grading and Erosion control Plan V_2.pdf Markup Summary

FINAL
SITE GRADING
TYPICAL ROADWAY SECTIONS

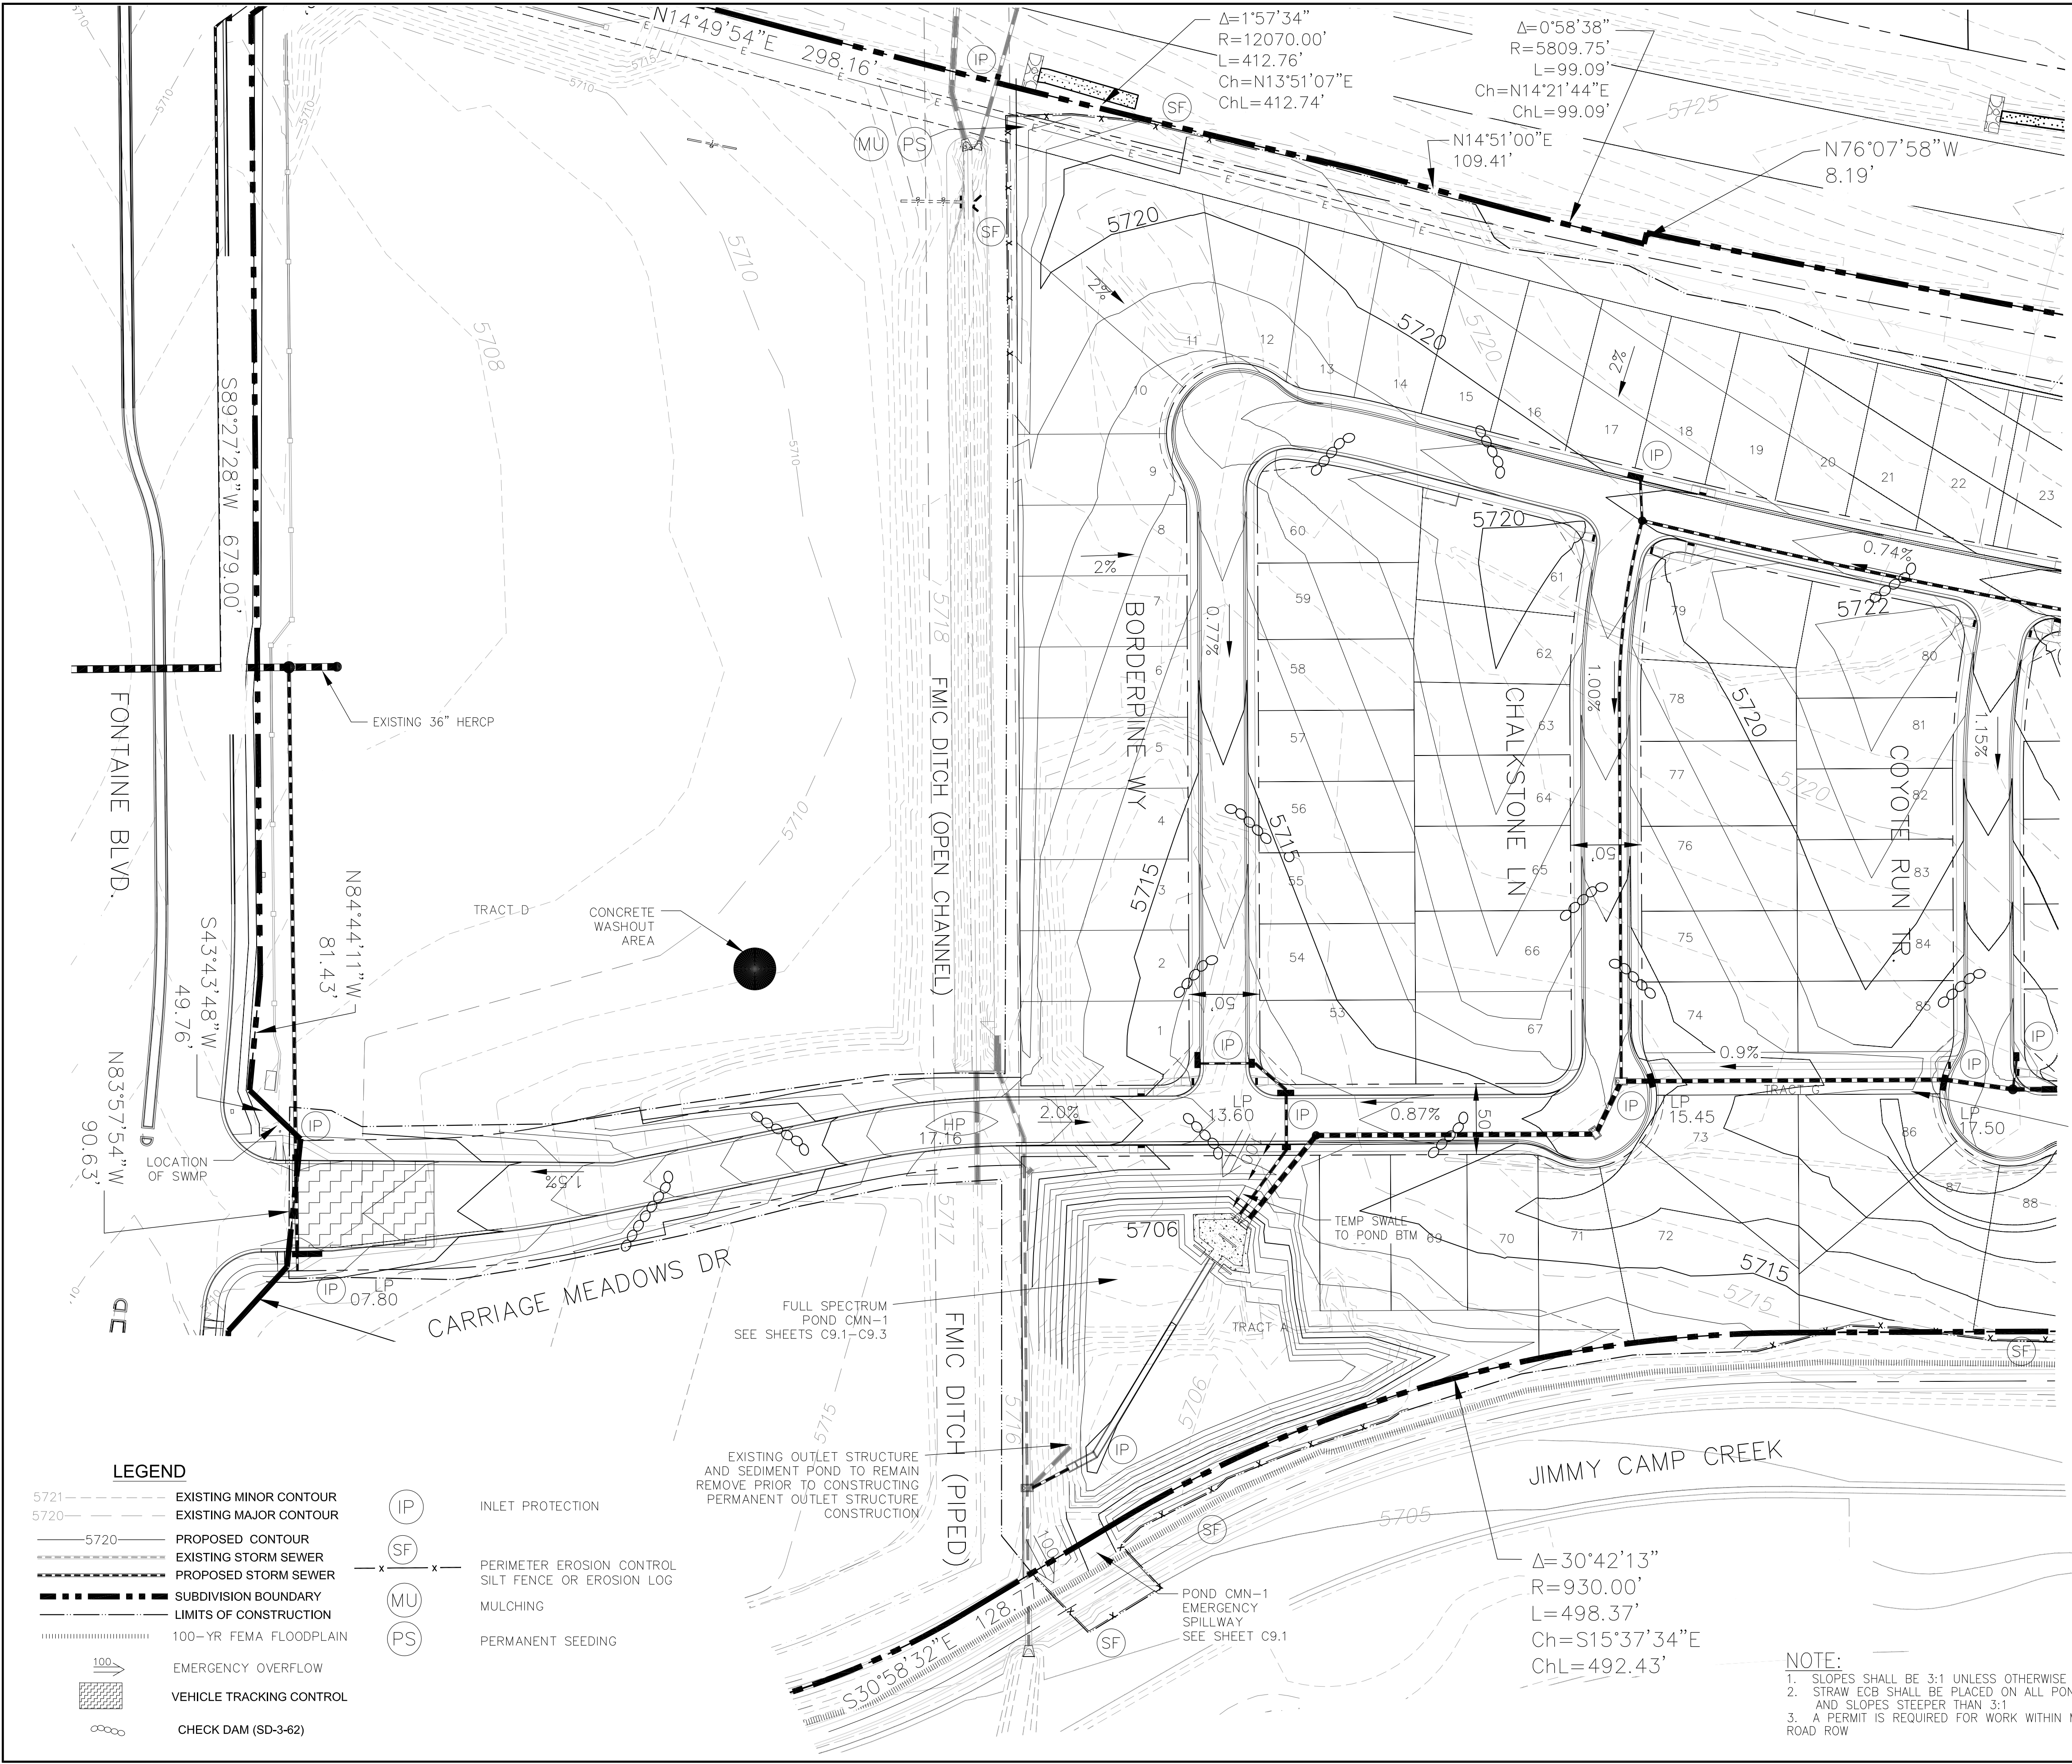
Replace geotech report note, missing.

EROSION CONTROL PLAN

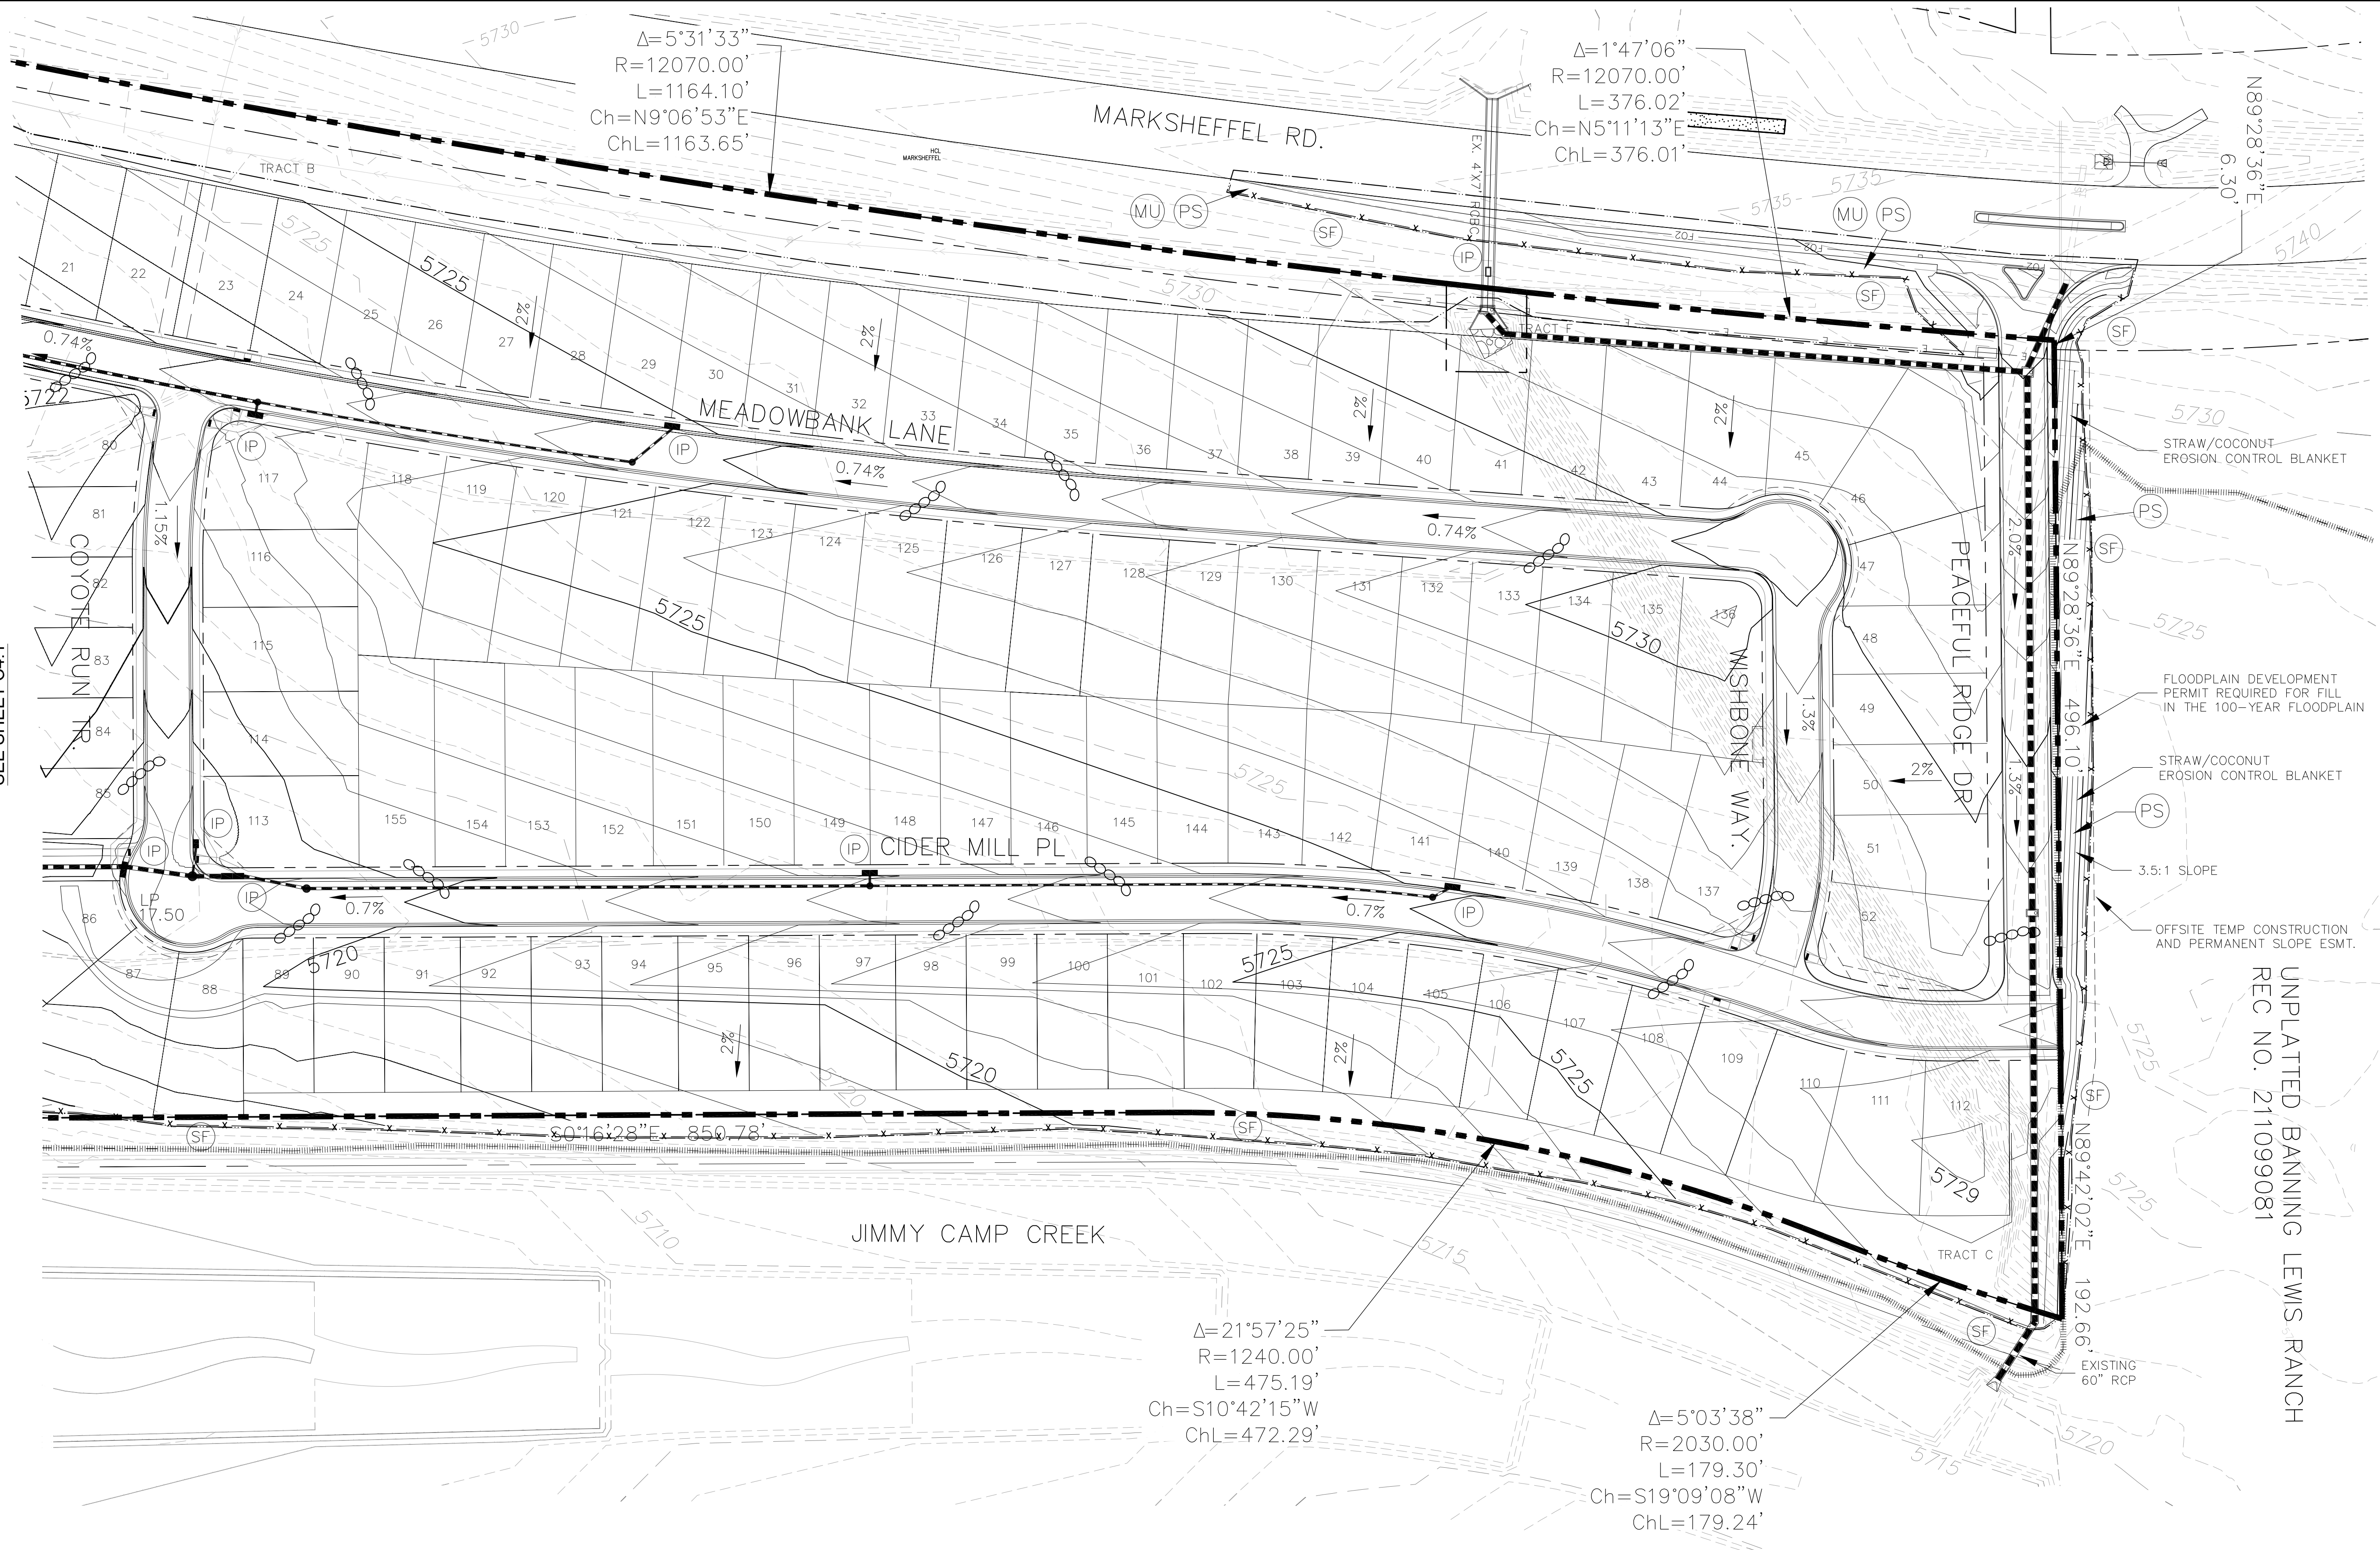
Show and label swale and BMPs
